## **CENTRAL PRECINCT DETAILED DESIGN SSDA (SSD-10439) - RESPONSE TO REQUEST FOR INFORMATION #2**

This letter provides further response to items 2 and 3 of the Request for Information (RFI) letter prepared by the Department of Planning, Industry, and Environment (DPIE) dated 13 April 2021. This letter provides revised solar amenity information and is supplementary to the first RFI package issued to DPIE on 23 April 2021 for the assessment of SSD 10439, relating to the Waterloo Central Precinct Over Station Development (OSD).

## SOUTH EAST APARTMENT

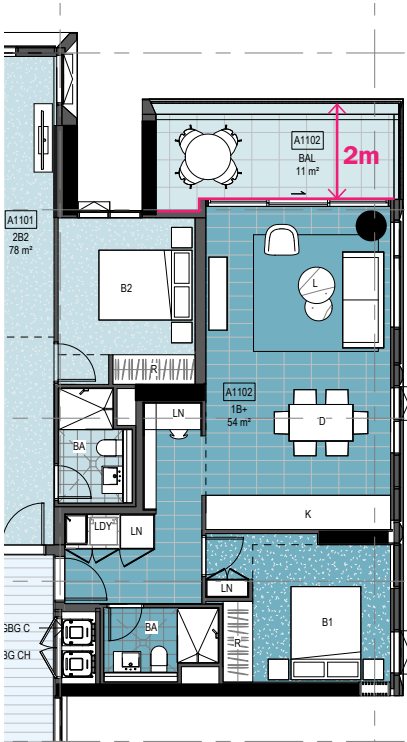
Revised Typical Floor Plate	Proposed Design Change	Solar Improvement compared to the original SSDA scheme
<p><b>SOUTH EAST APARTMENT</b></p>	<p>The living room glazing and balustrade line of the south eastern apartments is moved east by 240mm.</p> <p>Reshape and relocate south eastern column to be within the apartment.</p>	<p>Improved solar access to more than 1sqm of the living room by an additional 10 minutes between 9:00am and 11am in mid winter.</p> <p>Overall, solar amenity is improved for <b>19 additional</b> south east apartments between level 3 and level 21, which all receive 1 hour and 40 minutes of solar access.</p>

Solar improvement is evident for the south eastern corner apartment. When compared to the original SSDA scheme, the revised scheme results in an improvement by an additional 10 minutes of direct solar access to more than 1sqm of the living room of the affected south eastern corner apartments. Improvement is also achieved for the western apartment. When compared to the original SSDA scheme, the revised scheme results in an improvement by an additional 50 minutes of direct solar access to more than 1sqm of the private open space of the affected western apartments.

## WEST APARTMENTS

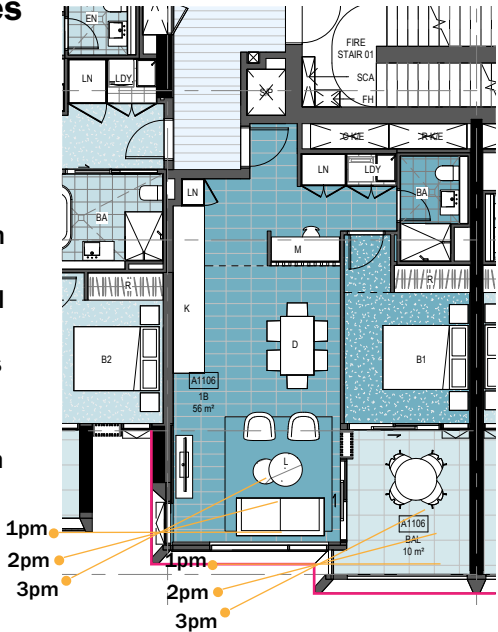
WEST APARTMENTS		
	<p>Adjustment to the west facing 1 bedroom apartment façade (shifted east by 700mm) to create north facing frontage to the adjacent private open space.</p>	<p>Both the living room and private open space of the 1 bedroom apartments between level 6 and level 19 achieve more than 1 sqm of solar access for 1 hour and 50mins between 1:10pm and 3:00pm mid winter. This was a balance between solar access to both areas.</p> <p>The private open space will also now receive direct sunlight for more than 2hrs, while solar access was only achieved in the original SSDA scheme for 1 hour and 15min.</p> <p>Overall, solar amenity is improved for <b>14 additional west apartments</b> between level 6 and level 19, now receiving at least 1 hour and 50 mins of solar access.</p>
EAST HIGH RISE APARTMENTS - LEVEL 20 AND 21		
	<p>East facing 2 bedroom apartments living room glazing shifted to the east by 1m.</p>	<p>Both the living room and private open space of the 2 bedroom apartments on level 20 and 21 receive more than 1sqm of solar access for 2 hours between 9:00am and 11:00am mid winter</p> <p>Overall, this design change enabled <b>two additional east facing apartments</b> to be fully compliant with ADG solar requirement, and will receive 2 hours of solar access to both living room and private open space between 9:00am and 3:00pm mid winter.</p>

### Proposed Design Changes to West High Rise Apartment

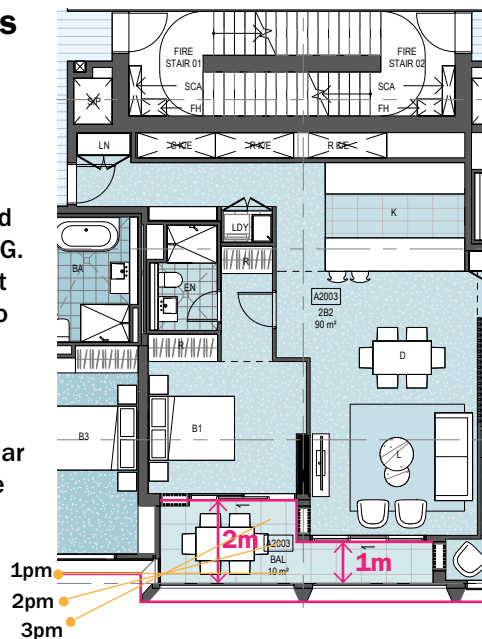
**WEST HIGH RISE APARTMENTS - LEVEL 20 AND 21**

The living room glazing is shifted east by 1m. The bedroom of adjacent apartment to shift east 700mm to allow north facing frontage for the private open space.

Solar is received to the living room from 1.55pm to 3pm, this is an improvement of 20min of solar compared to the original SSDA scheme.

Solar is received to private open space for the full two hours between 1pm to 3pm, this is an improvement of 15min of solar compared to original SSDA scheme.

Living room and private open space both receive 1sqm of solar access for 50min between 2.10pm to 3pm.
